**Ref: Re-submission of EP/89/18/HH Loft Conversion and Single Storey Rear Extension.
39 Hillview Crescent, East Preston. West Sussex, BN16 1RG.**

DRW NO 8a SCALE 1/50 (A3)
PROPOSED SECTION

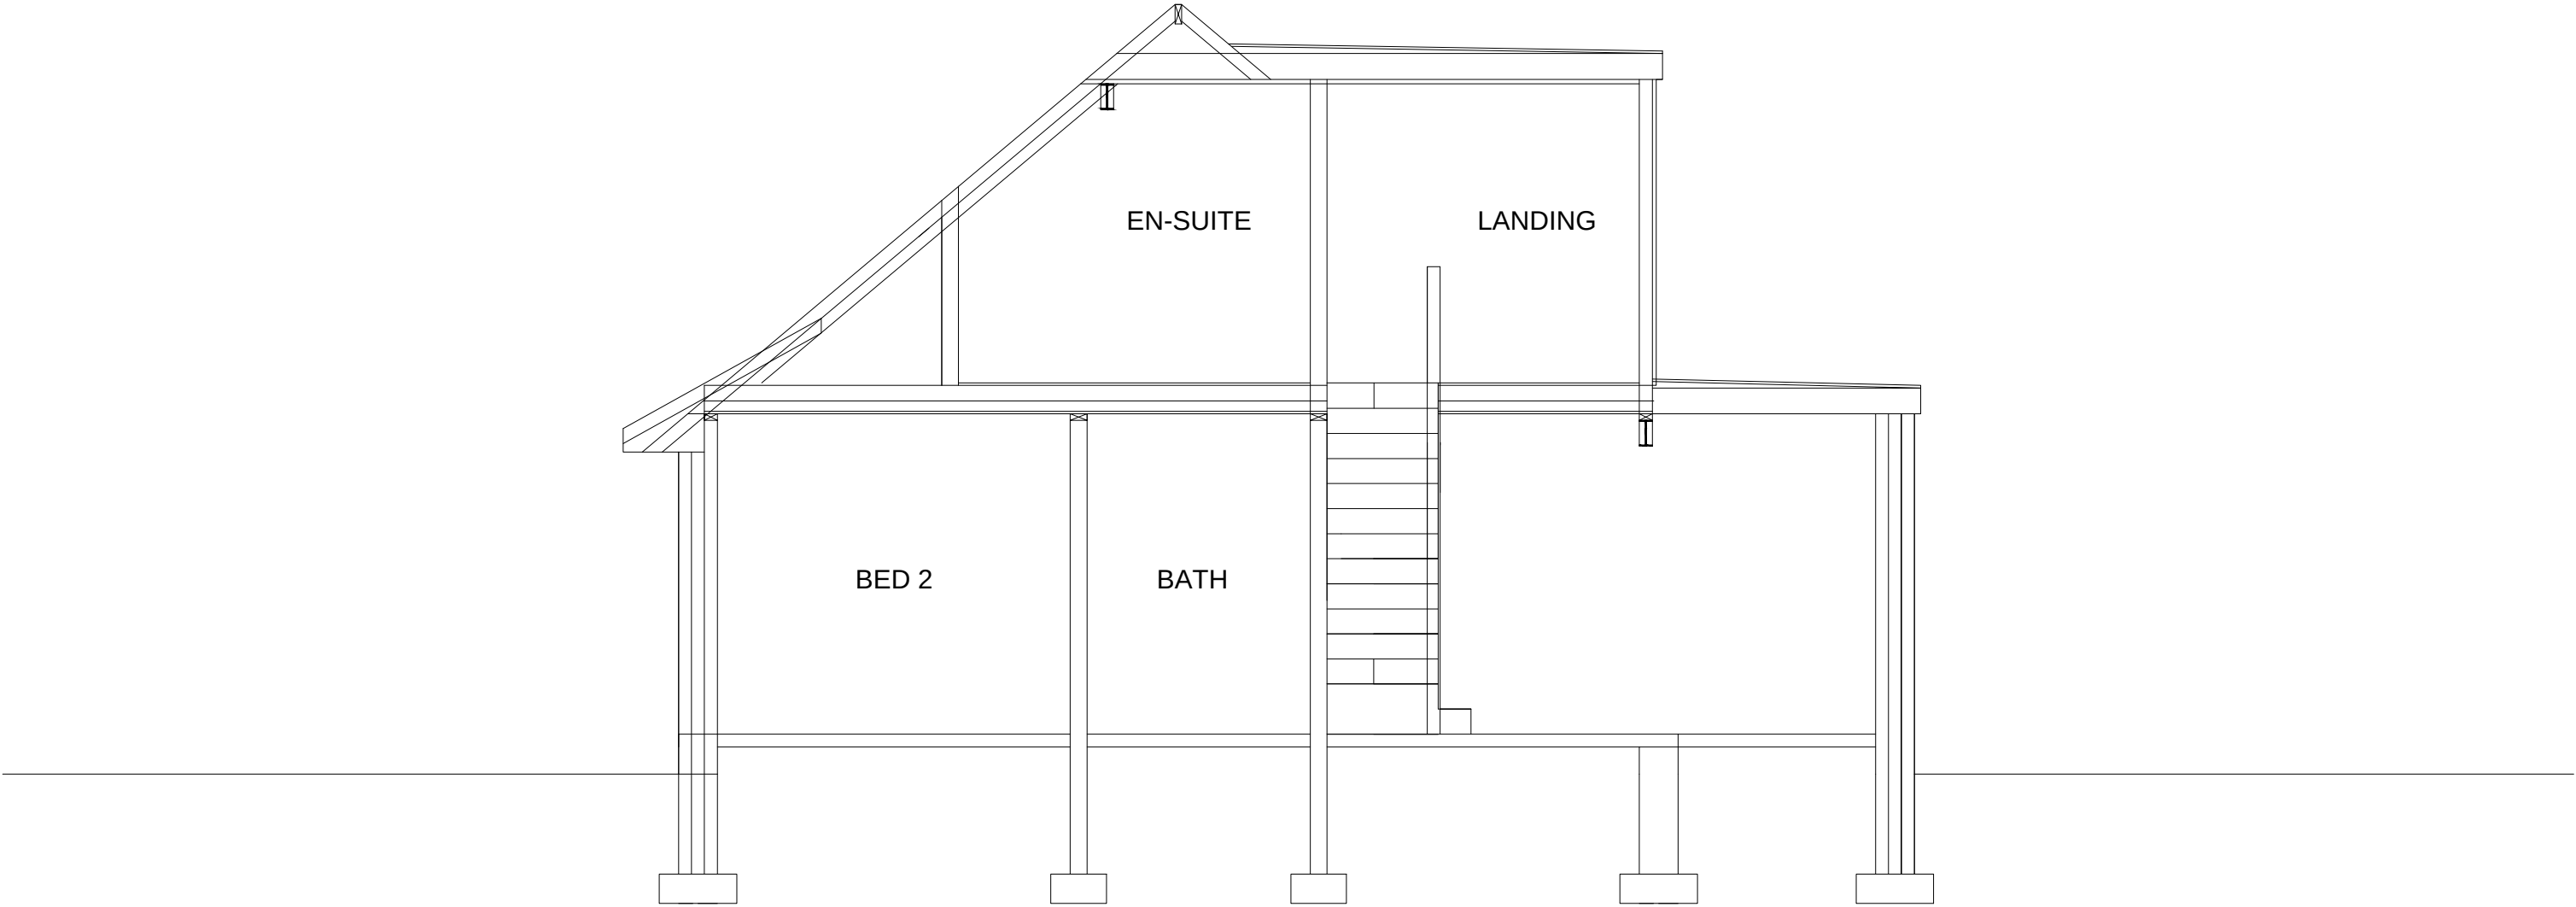
1. The full gable ends have been changed to barn ends / half hips to soften the corners and give a less square appearance to the front elevation.
2. An additional velux roof light has been provided on the left hand side of the front elevation to give a more symmetric appearance.
3. I can also confirm that the existing ridge height will not be raised in height.
